KITTITAS COUNTY COMMUNITY DEVELOPMENT SERVICES

February 23, 2010

RE: Hedrick Short Plat (SP-09-00008)

The Kittitas County Community Development Services Department has determined that the Hedrick Short Plat (SP-09-00008) is a complete application and hereby grants *conditional preliminary approval* subject to the following conditions:

SP-09-00008

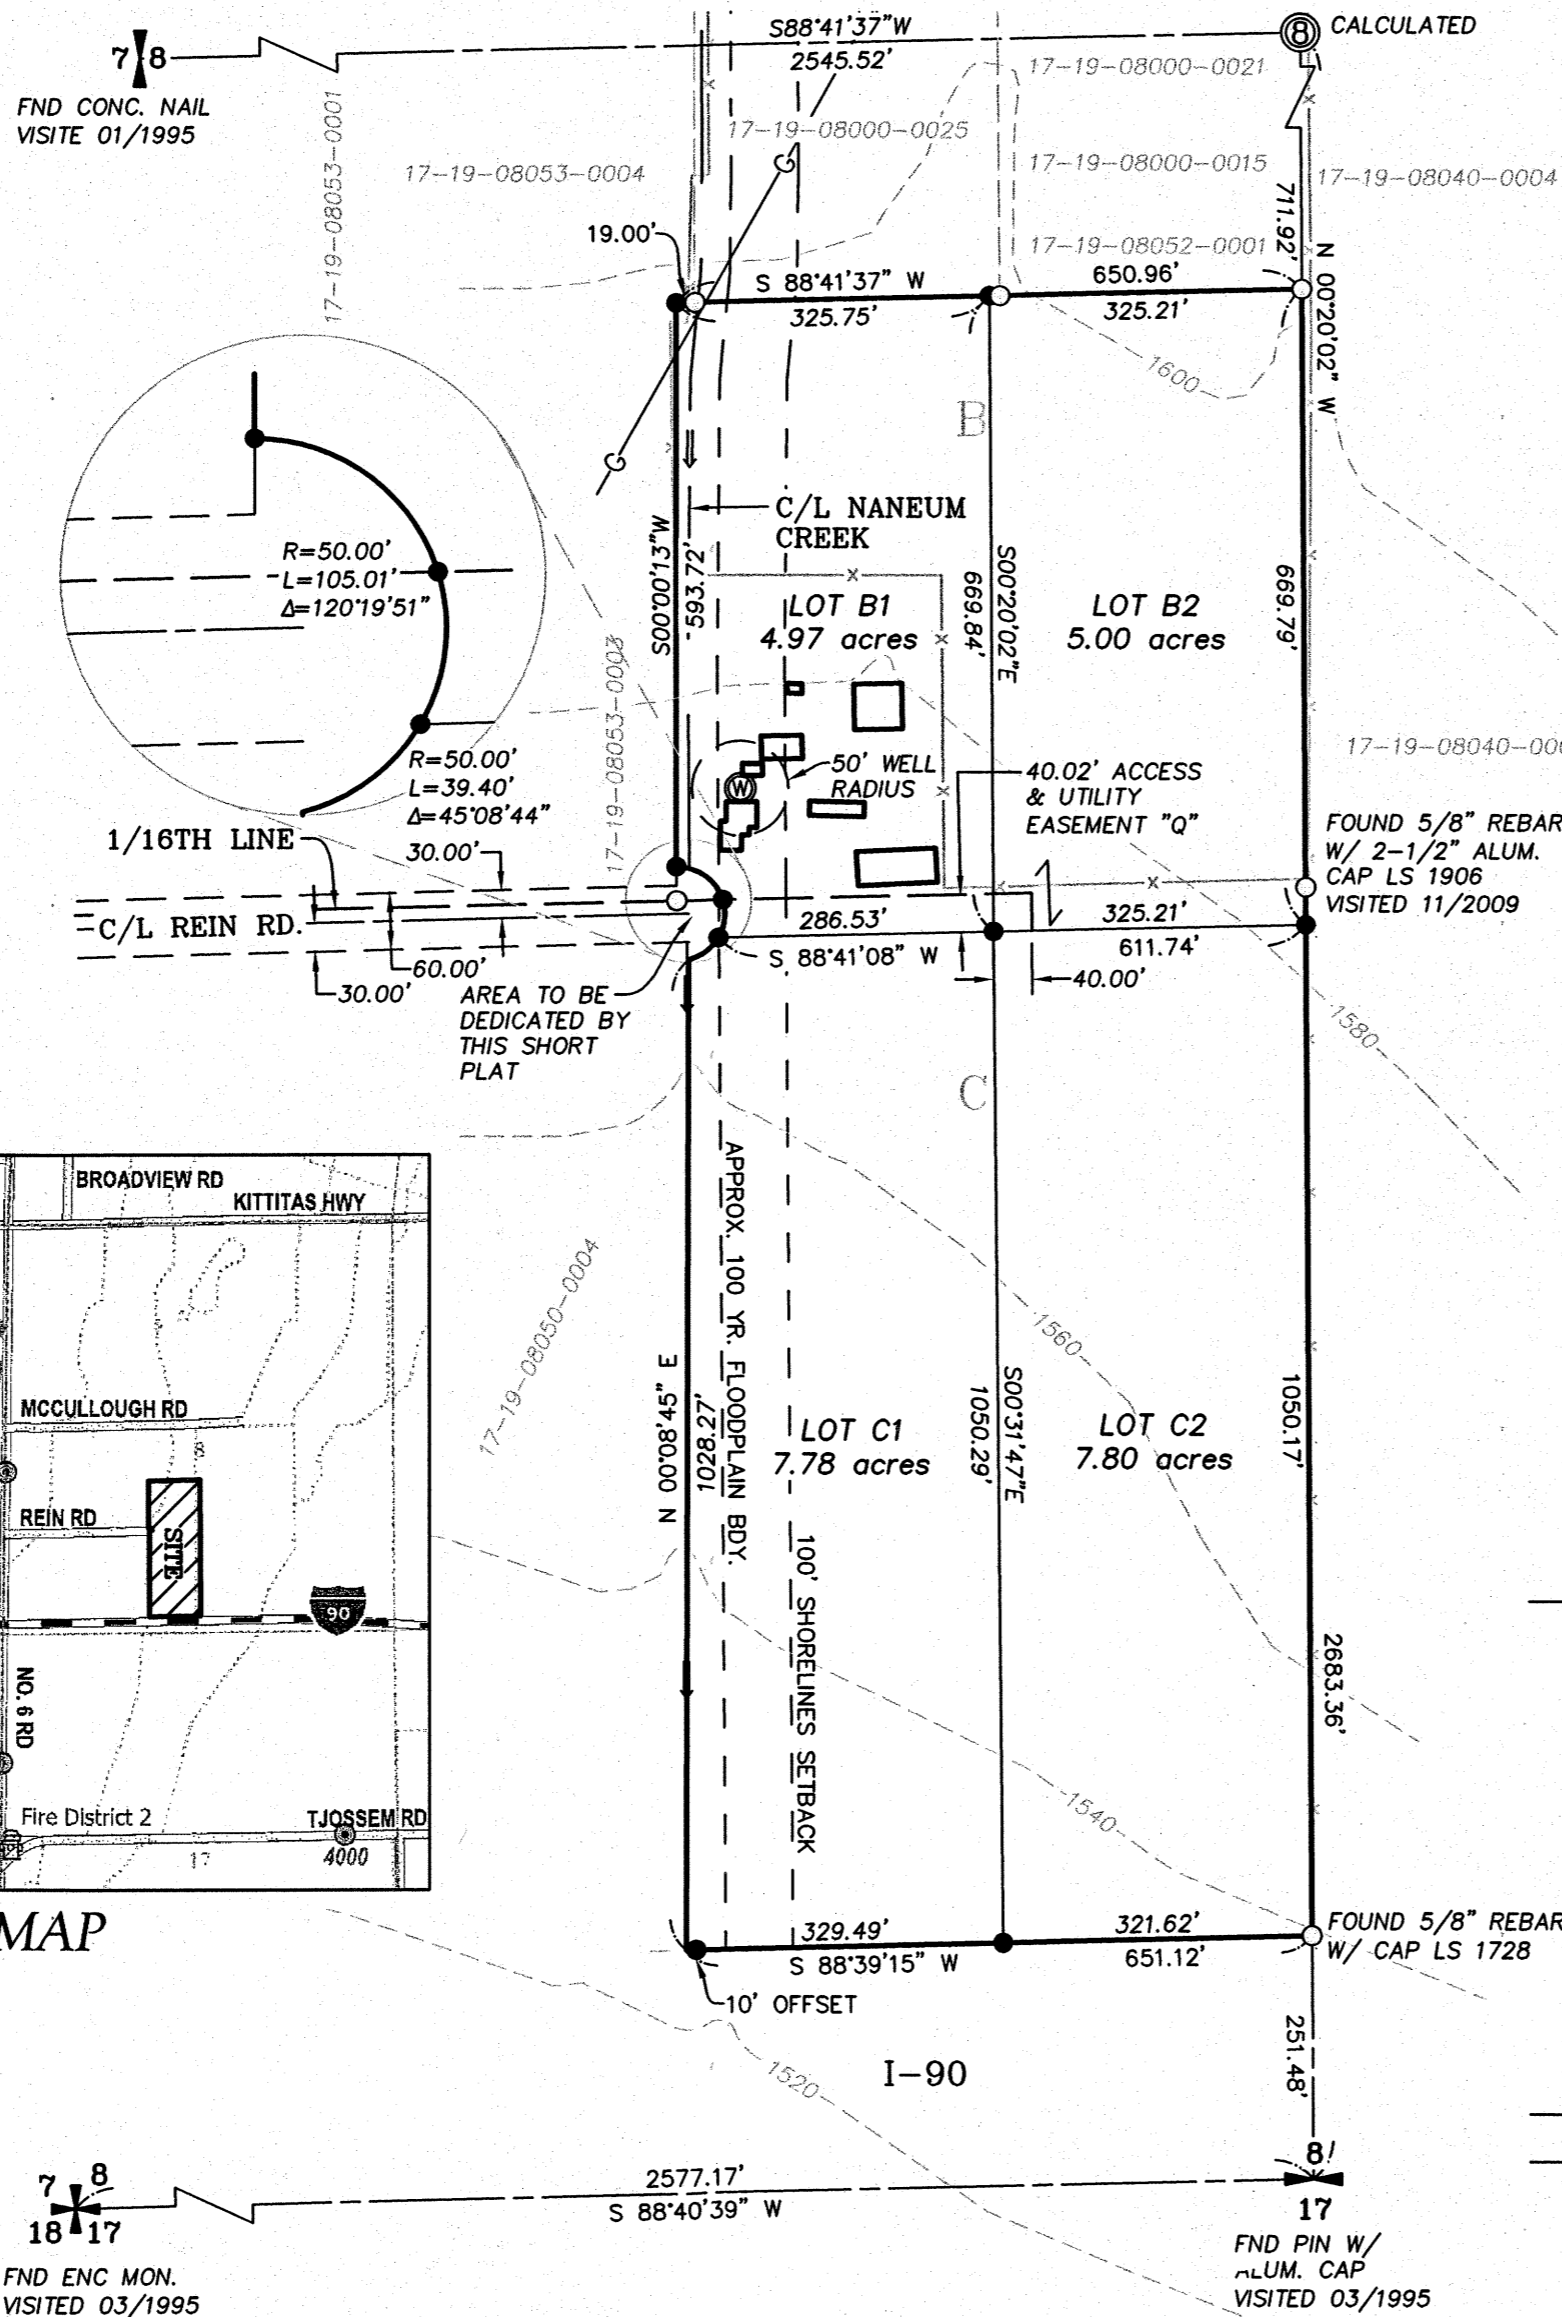
1. Both sheets of the final mylars shall reflect short plat number SP-09-00008 and an accurate legal description shall be shown on the face of the final plat.

2. Full year's taxes must be paid on all tax parcel numbers per requirement of the Kittitas County Treasurer's Office.
3. The following plat notes shall be recorded on the final mylar drawings:

- All development must comply with International Fire Code.
 - This short plat has exhausted the use of the one time split provision allowed per Kittitas County Code. No further one time splits are allowed for the subject parcels and subsequent parcels created via this short plat.
